Town & Country Planning Act 1990 (as amended) s211 Notice

Prior Notification of Work to Tree(s) in a Conservation Area

Development: Hornbeam - reduce 1 No. Hornbeam to previous pruning points. Silver Birch - reduce 1 No. Silver Birch to previous pruning points within Craigwell House, Aldwick Conservation Area.

Location: Mallards 18 The Drive Bognor Regis West Sussex PO21 4DU

SKP 1 Sketch plan showing location of trees

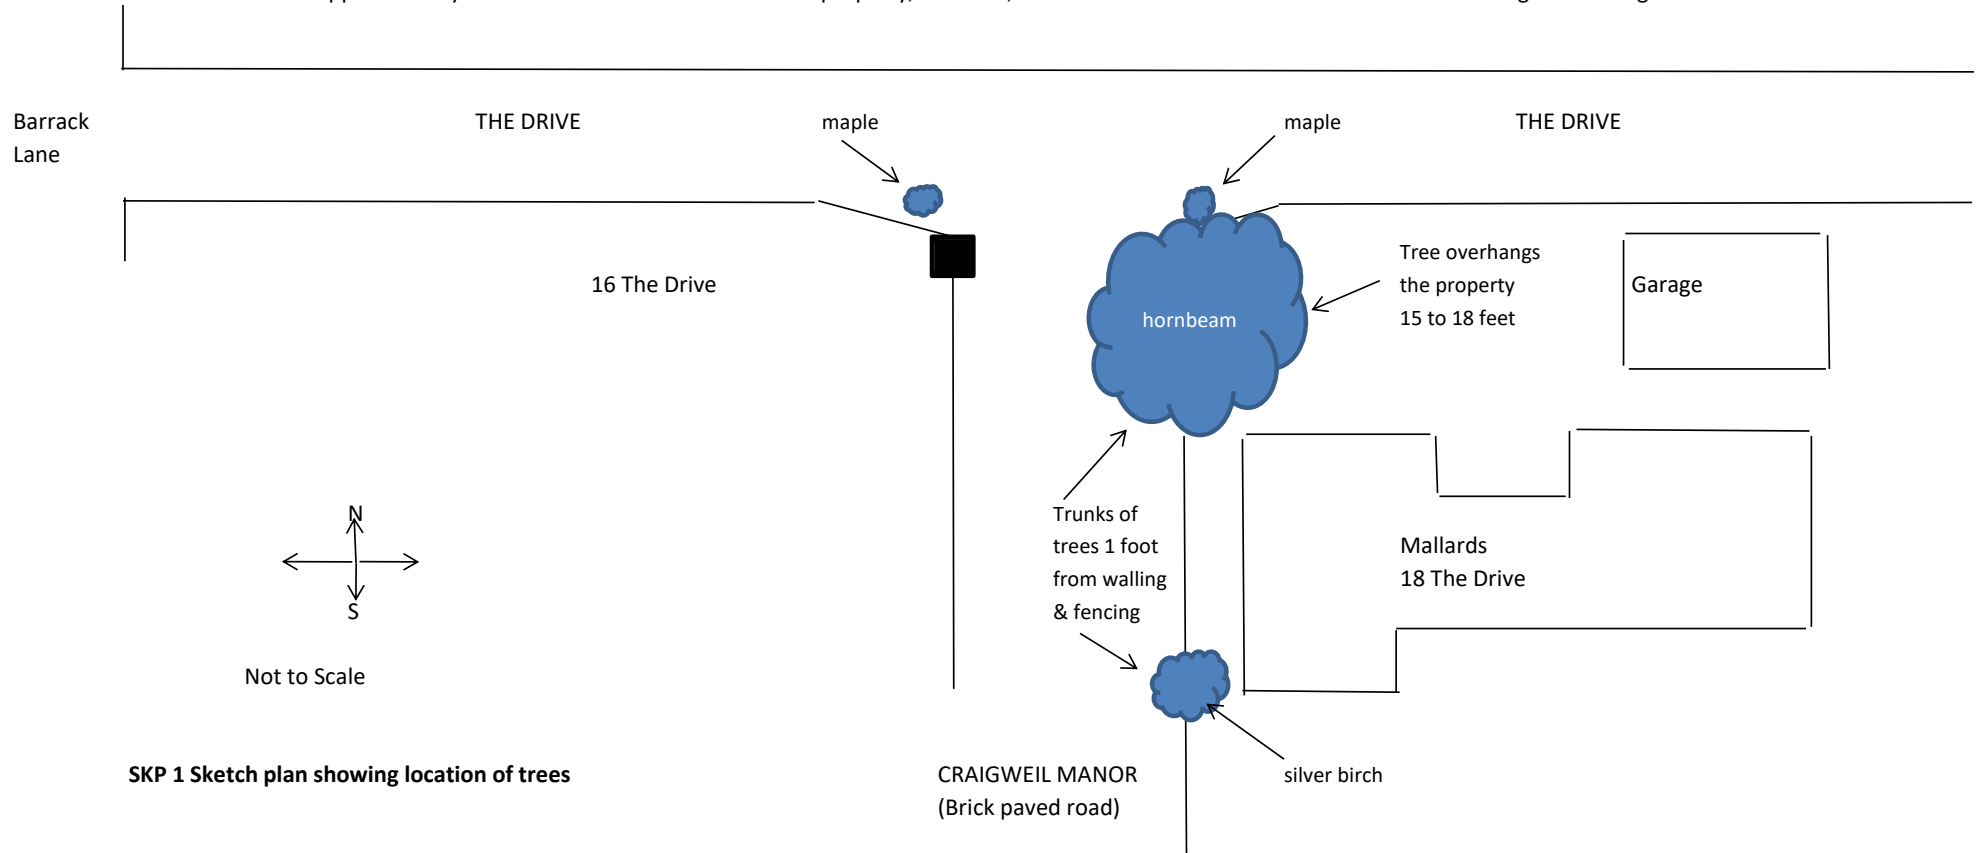
If proposing a crown reduction please provide the height and spread of both trees, in meters, after the reduction has taken place.
